Our ref: A417
Your ref: TR010056

A417 Missing Link Development Consent Order

Application for a non-material change to an accepted Development Consent Order to include additional land for compulsory acquisition

Scale	1:2500	By	HS	Checked	AK	Approved	JP	Authorised	JP
Original Size	A1	Date	14/02/22	Date	14/02/22	Date	14/02/22	Date	14/02/22
Drawing Number	HE PIN HE551505 - ARP X_XX_XXXX_X	Originator	ARP	Volume	ELS -DR-LE-000101	Revision	C02

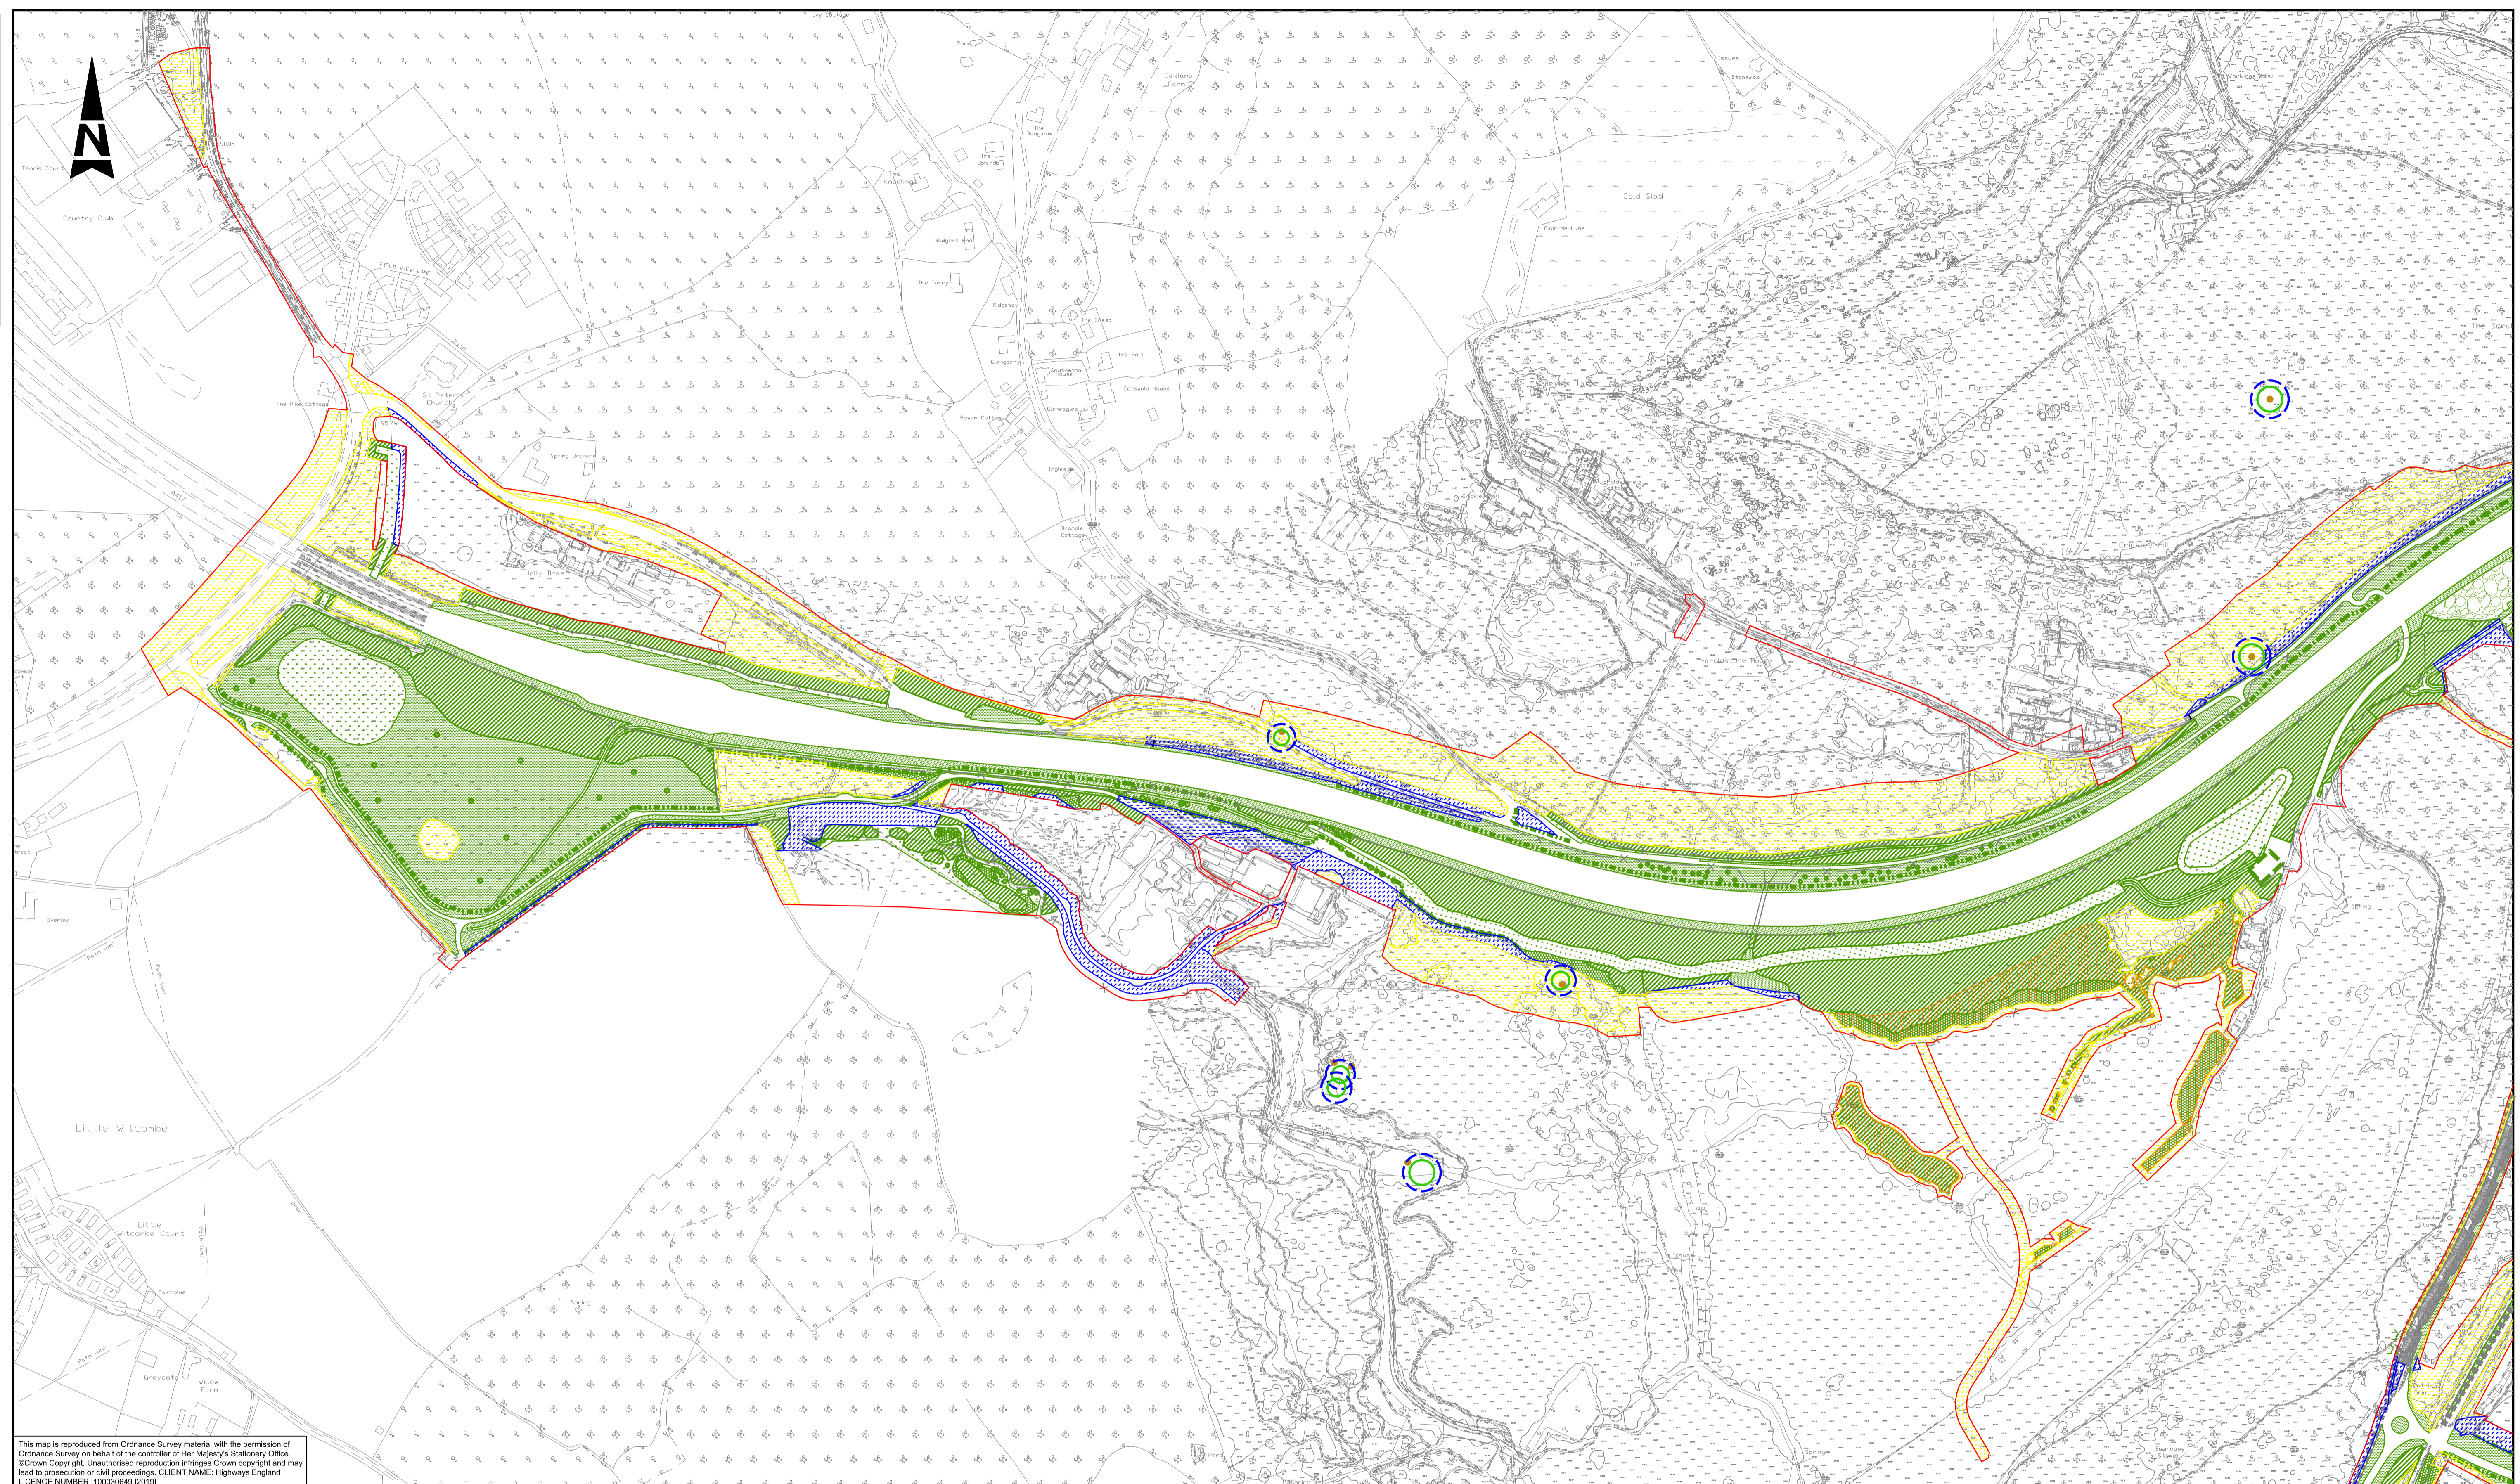
- (b) Mitigation planting proposed to offset vegetation loss along the A417 is to be relocated to the southern edge of the A417 to the plot southwest of Flyup business, adjacent to existing downhill bike tracks. Given this mitigation would be relocated as part of the change, no material change to likely significant effects presented in the ecological assessment is expected (Document Reference 6.2, Chapter 8, APP-039).

| Document | Reference | Change(s) |
|---|---|---|
| Environmental Statement Figure 7.9 – Retained Vegetation (Sheet 1 of 6) | Document Reference 6.3, Rev 1 | Changes made to reflect proposed changes to areas of mitigation planting. |
